Our ref: OUT25/8157

Subject: Hillview Hard Rock Quarry (SSD-70557215) – Environmental Impact Statement

### Detailed advice to DPHI Planning & Assessment regarding the Hillview Hard Rock Quarry (SSD-70557215) – EIS

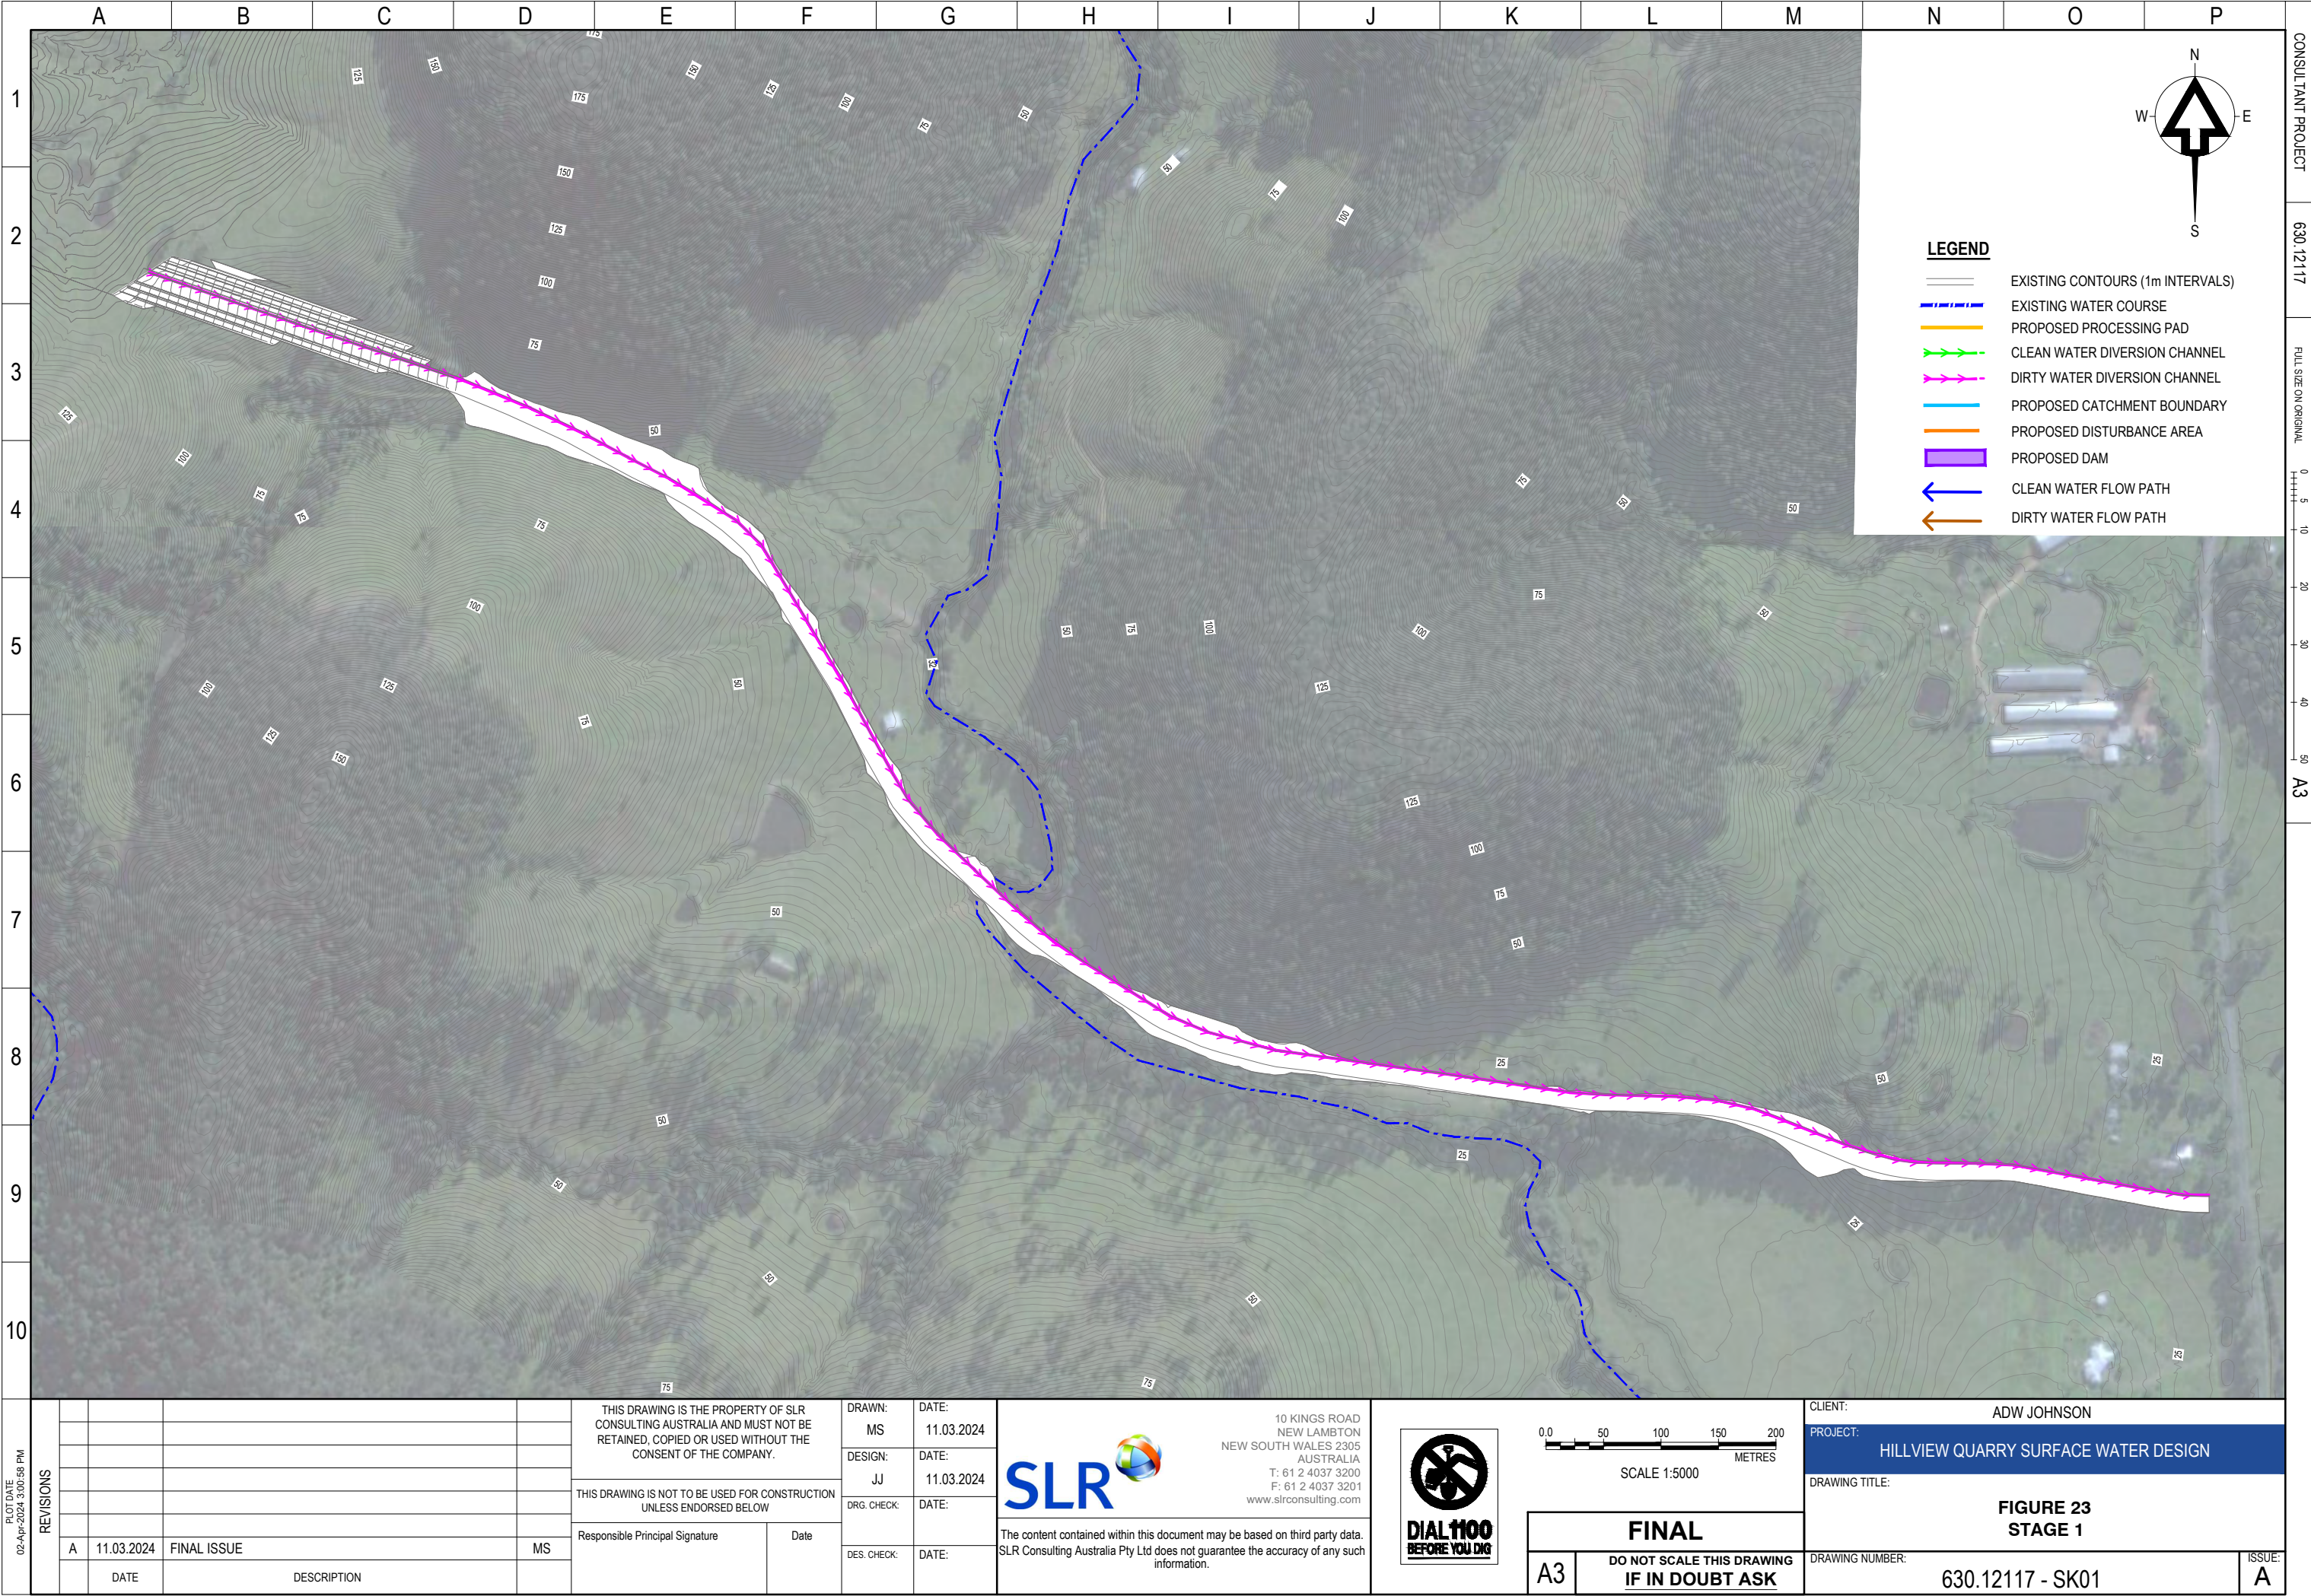
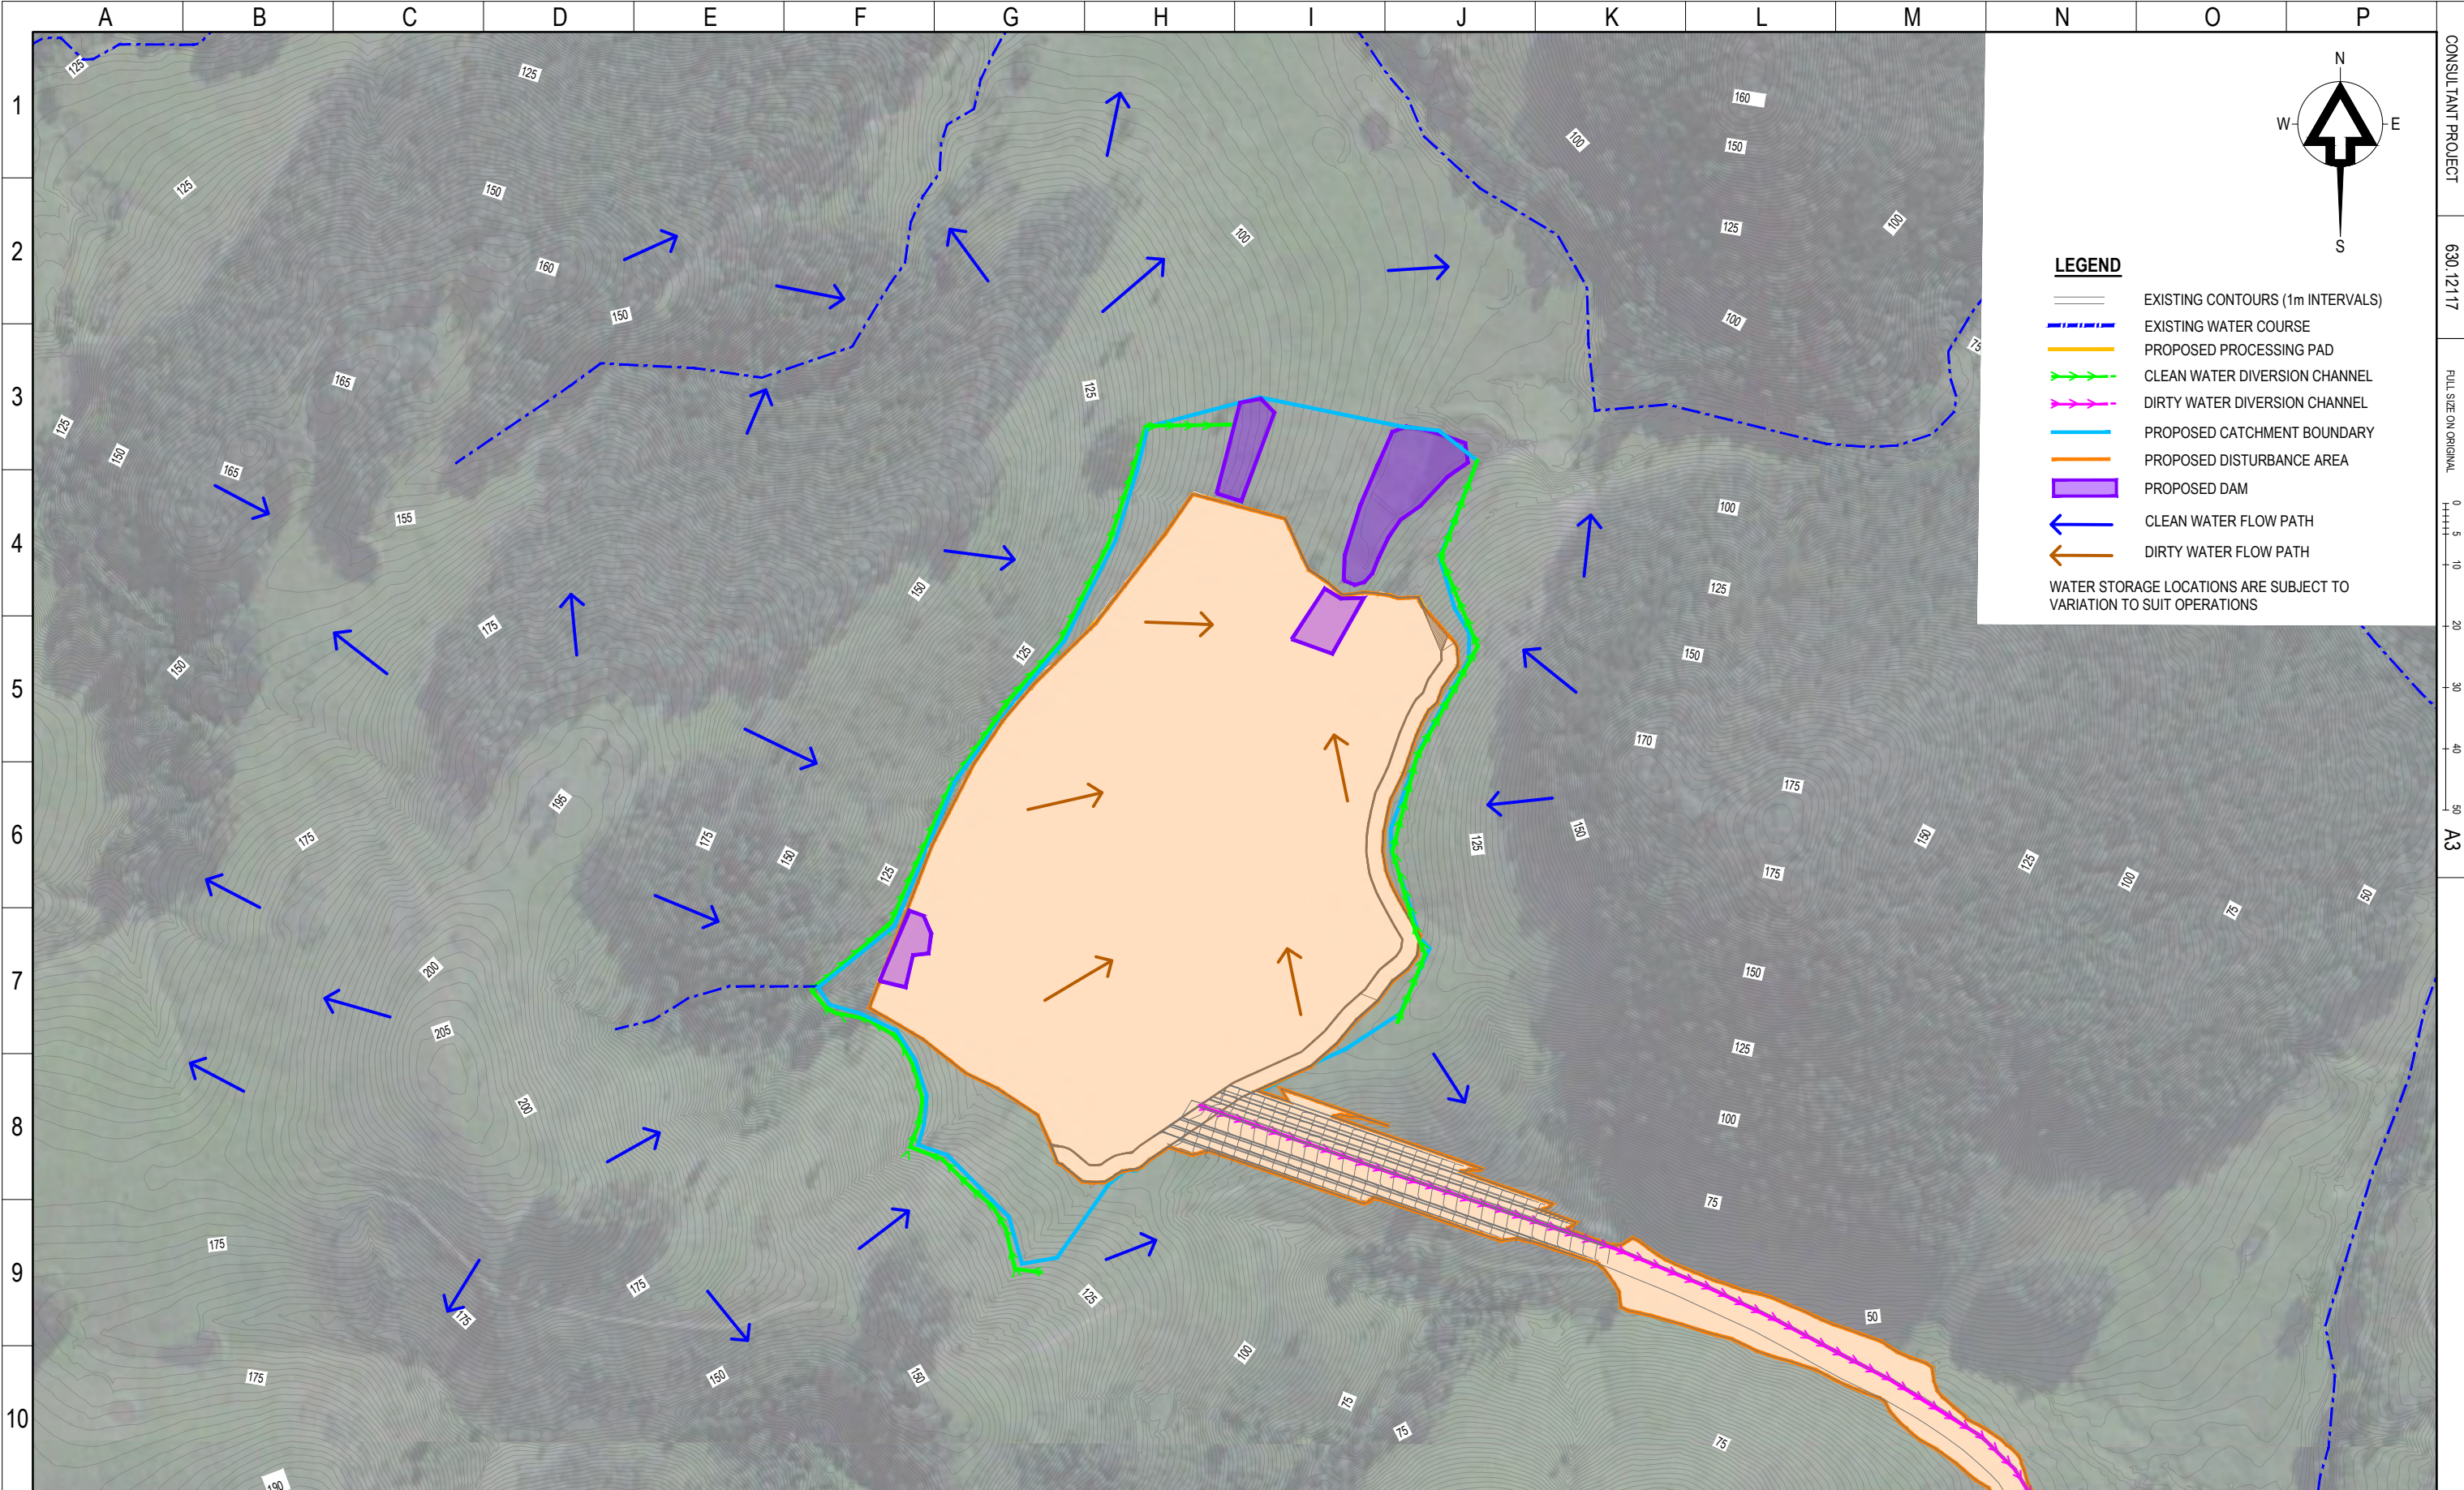
The proposal includes several dams/basins which need to be considered against the water licensing framework. This should consider the harvestable rights capacity, exclusions under Schedule 1 of the *Water Management (General) Regulation 2018* or the requirement to obtain entitlement. Figures 24-29 and 49 of the Surface Water Assessment show that an existing 'Farm Dam' is proposed to be converted to a sediment dam at the outlet of the quarry. This dam is on a third order stream so would not meet the definition of an excluded work under Schedule 1 of the WM (General) Regulation as it is not located on a minor stream.

Dams on third order watercourses do not meet the Departments Guidelines for Controlled Activities on Waterfront Land – Riparian Corridors. It is generally requested that water quality treatment occurs offline.

The Department of Planning, Housing and Infrastructure request the proponent to review the proposed surface water structures to confirm the requirement for water licensing or where an exemption may apply. This is to include a review against:

- The excluded work provisions under Schedule 1(4) of the Water Management (General) Regulation 2018. Further information is available at: [https://water.dpie.nsw.gov.au/\\_data/assets/pdf\\_file/0008/554444/excluded-work-exemption-fact-sheet.pdf](https://water.dpie.nsw.gov.au/_data/assets/pdf_file/0008/554444/excluded-work-exemption-fact-sheet.pdf)
- Maximum harvestable rights dam capacity where dams are located on minor streams and capture runoff.
- The requirement for licensed entitlement where the water capture/use is not exempt or excluded, and to demonstrate this can be obtained in the relevant water source.
